**RE: CITY EAST ZONE SUBSTATION PROJECT APPLICATION 2A(i)
20-26 O'CONNELL STREET AND 33-35 BLIGH STREET, SYDNEY**

**RE: CITY EAST ZONE SUBSTATION PROJECT APPLICATION 2A(i)
20-26 O'CONNELL STREET AND 33-35 BLIGH STREET, SYDNEY**

We act on behalf of the Lowy Institute of International Policy located in the former heritage listed NSW Club Building at 31 Bligh Street, Sydney. We are writing this submission as an objection to the current major project application known as the City East Substation Project Application 2A(i) lodged by Energy Australia with the Department of Planning.

This application 2010

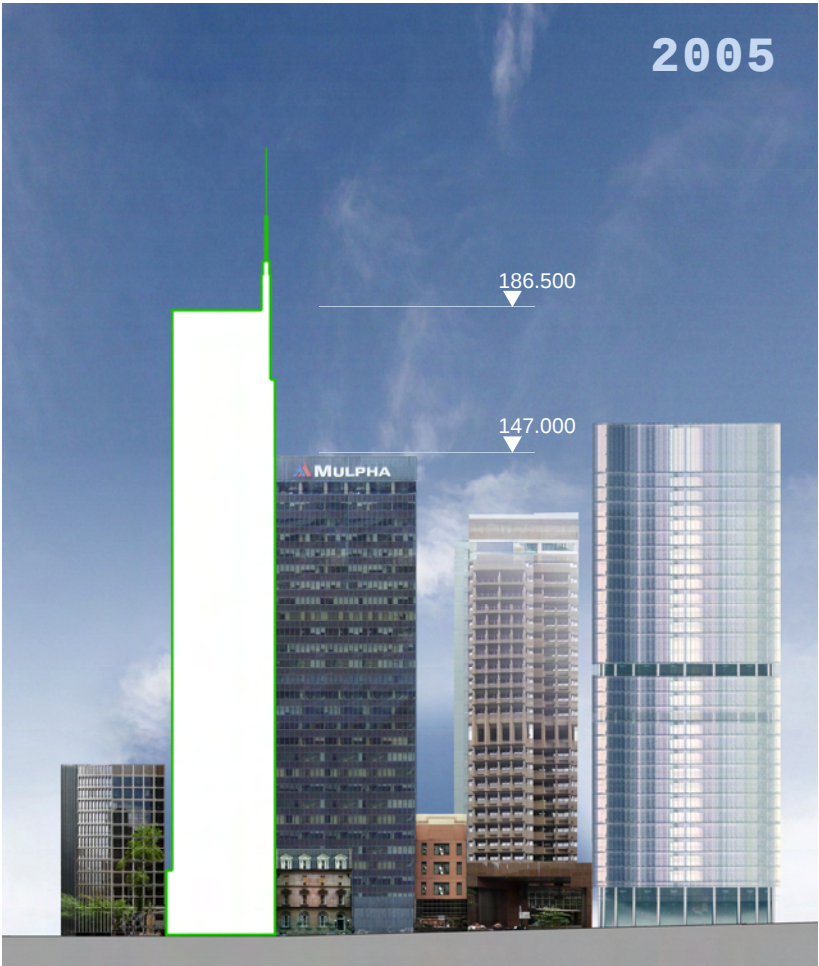
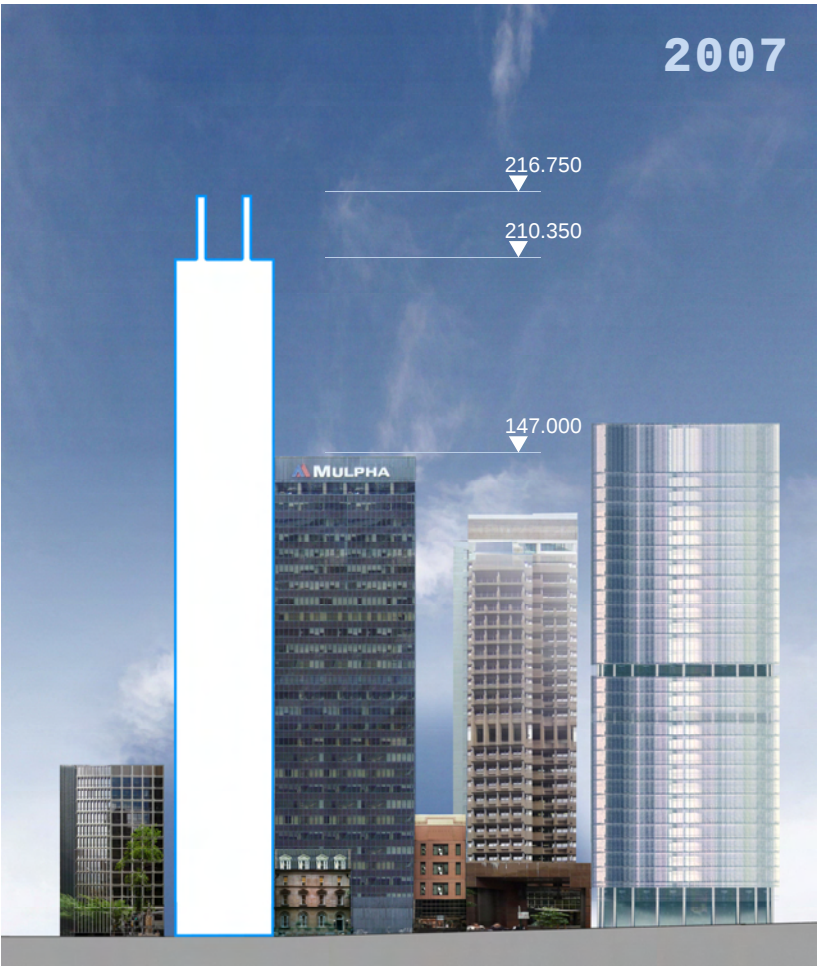
A comparison between the previously approved scheme and the proposed City East Zone substation development is illustrated in the attached photomontages (**Figure 2a and 2b**).

5.2.6. O'Connell Street Level 05 Plan

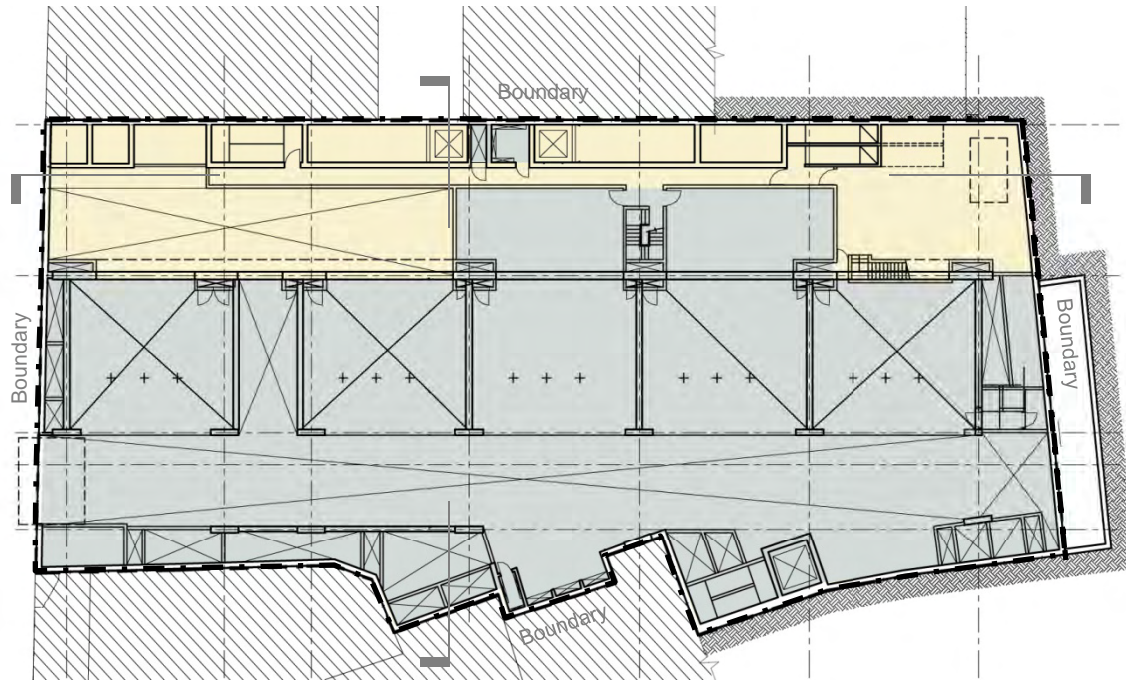
One of the key components of the proposed building envelope on the site is the proposal to establish 5 transformers at ground level with vehicle access from O'Connell Street. The Energy Australia proposal includes the design of these 5 transformers in one line extending from the O'Connell Street frontage to the Bligh Street frontage of the site as illustrated in the extract from the application in Figure 3 below.

In comparison to the Belmore Park Zone Substation, the proposed transformers on the subject site are squeezed into a space between two commercial office buildings with little opportunity for refining design to achieve setbacks from adjoining boundaries. The proposal is within a significantly denser locality being in the heart of the CBD and surrounded by commercial development and public plaza areas. The proposal seeks to bring people into the site for the commercial development and includes a public foyer space and lifts immediately adjacent to the substation.

We request that prior to any further assessment of the current application or any consideration of a building envelope on the site that Energy Australia provide an alternate design solution that responds more appropriately to the significant planning constraints of the site.

5.3.2. Bligh Street Level 07 Plan

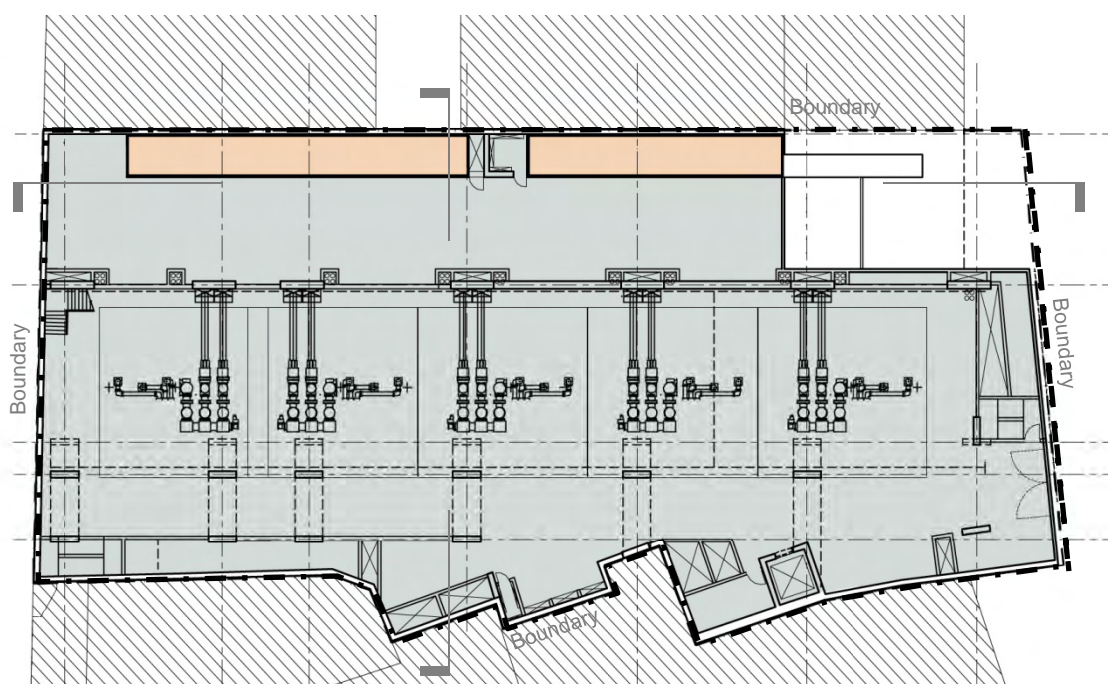
The proposed building envelope indicated within the current Stage 2A(i) application will provide a substantial built mass to the street frontage that will reinforce the substation as the 'solid' within the streetscape, will further dwarf the heritage listed public open space area and obscure views to the heritage listed Lowy Institute building from Bligh Street and Richard Johnson Square. The proposed substation building is an unarticulated box which is being 'dumped' within this sensitive streetscape.

The eight storey high vertical slot currently proposed adjacent to the Lowy Institute building is a tokenistic attempt to address heritage issues that will appear as a 'mass scar' in the built form along Bligh Street rather than enhance the quality and definition of public domain that integrates with Richard Johnson Square and complements the adjoining significant heritage building within the streetscape. It is not an appropriate through site link between Bligh and O'Connell Streets as it does not directly connect between the two streets and has no activity along its length.
